Consultation Response from KC, Highways Development Management
2026/91506 Land adj, 114, Marsh Lane, Shepley, Huddersfield, HD8 8AS
Erection of single storey rear extension and front porch to existing barn/outbuildings to form dwelling with associated internal and external works
Date Responded: 10 July 2026
Responding Officer: Sheila Henley
Responding Ref: 12-32/20

Plan ref: (20)002 – Block Plan; (20)001 Proposed GA.

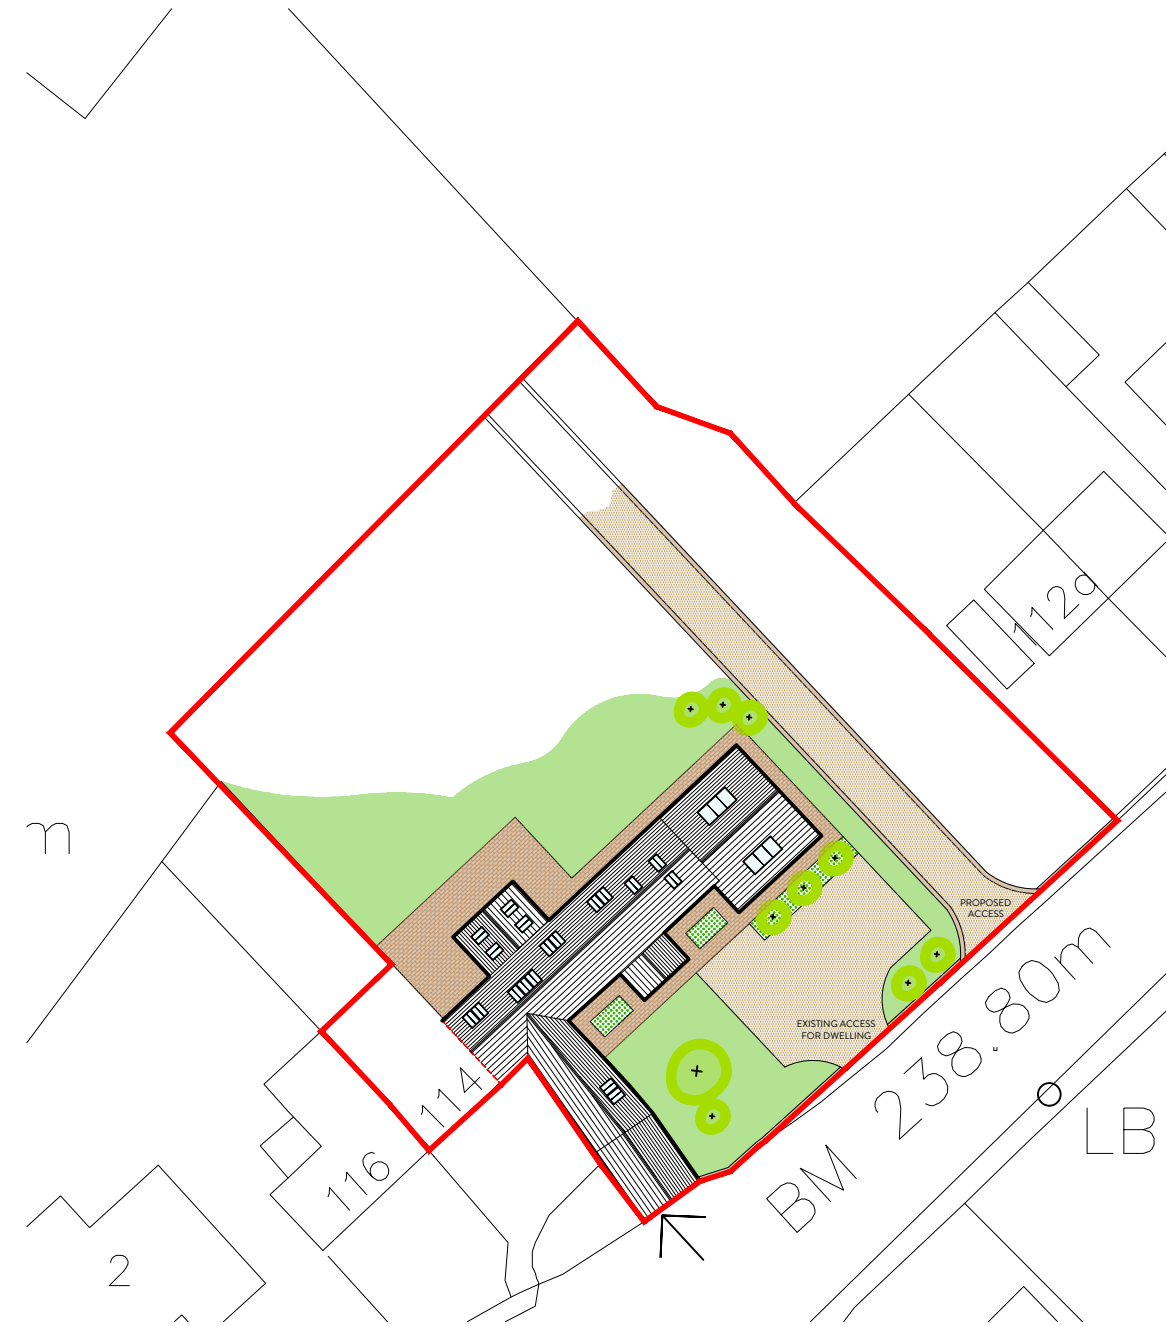
Any new hardsurfacing would require confirmation of materials to ensure no gravel tracks onto the highway and to be of a permeable type or there would be need for installation of a surface drainage scheme with submission of details for approval.

For the new agricultural access and track, these are not reflected in the description and seek to clarify whether this is considered permitted development. The Block Plans do not show the changes to form the track. Additionally, there is insufficient information to meet policy LP21 with an absence of detail on the layout and surfacing to demonstrate safe and convenient access and egress.

To establish that the access will be safe and convenient, details for approval are necessary of:

- i. Layout at a larger scale with dimensions annotated.
- ii. Visibility splays in each direction for the speed limit or based on 85th percentile speeds passing the site with no obstruction within the splay at a height not exceeding 1.0m.
- iii. Demonstration of turns into and out of the proposed access with parked vehicles indicated through a swept path analysis tracking a tractor and trailer or similar.
- iv. Any gating.
- v. Surfacing.
- vi. Details of the expected number and type of movements.
